June 26, 2024

**RE: P247 Multi-family Development Fishers Canyon: Thompson Thrift - City of Fountain
Review Comments**

Traffic Impact Study

FIGURE 4
 VENETUCCI THOMPSON THRIFT
 EL PASO COUNTY, COLORADO
 2025 BACKGROUND TRAFFIC VOLUMES

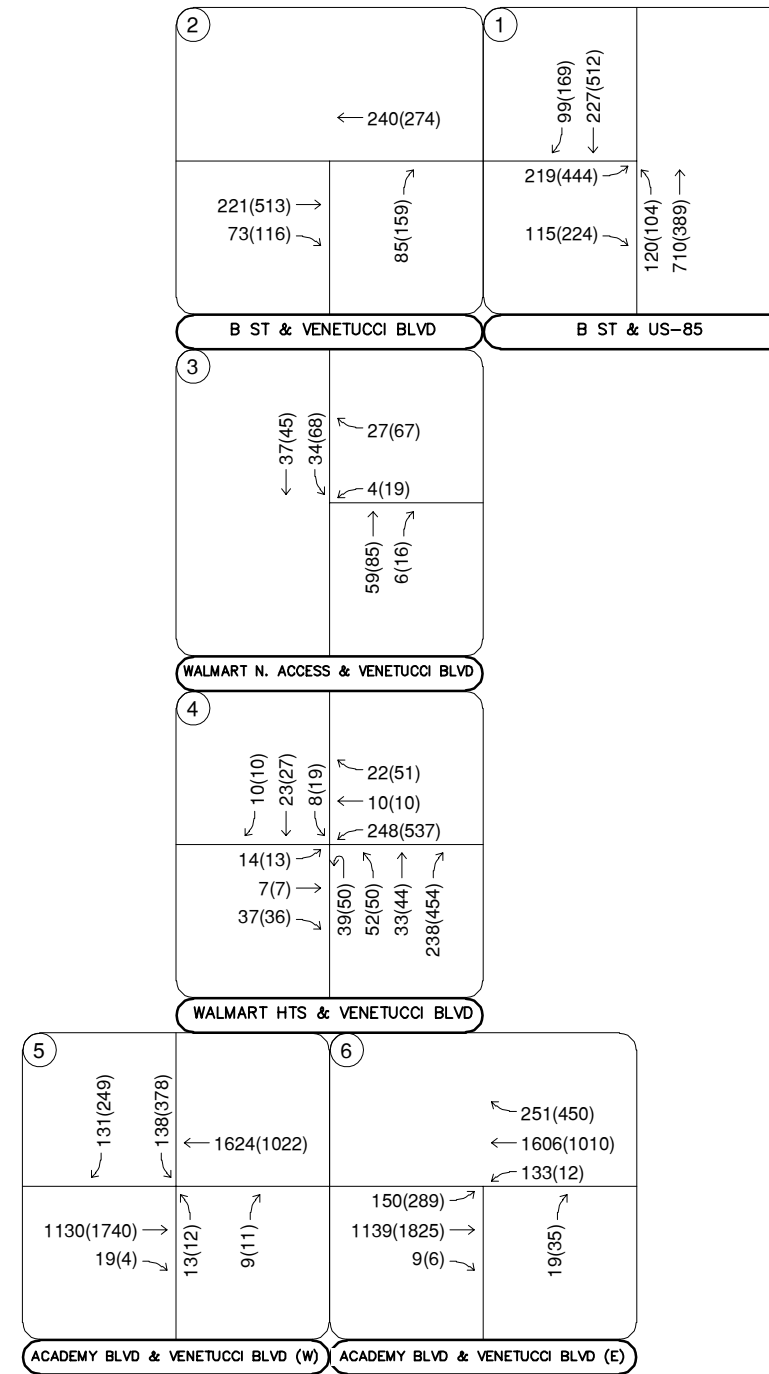
The Traffic Impact Study (TIS) must align with the Max Green Transportation Engineers' South Academy Highlands Traffic Study and Wilson and Company's detailed study of the Venetucci Boulevard and B Street Intersection. Appropriate growth factors for different roadway classifications must be used to forecast traffic volumes in 2023, 2025, and 2045. The South Academy Highland TIS should be used to verify trip generation, including both inbound and outbound trips. Lastly, the 4% project traffic contribution on B Street and Venetucci must be reevaluated, as Figure 4 of the TIS indicates a PM peak Volume of 116 instead of 5.
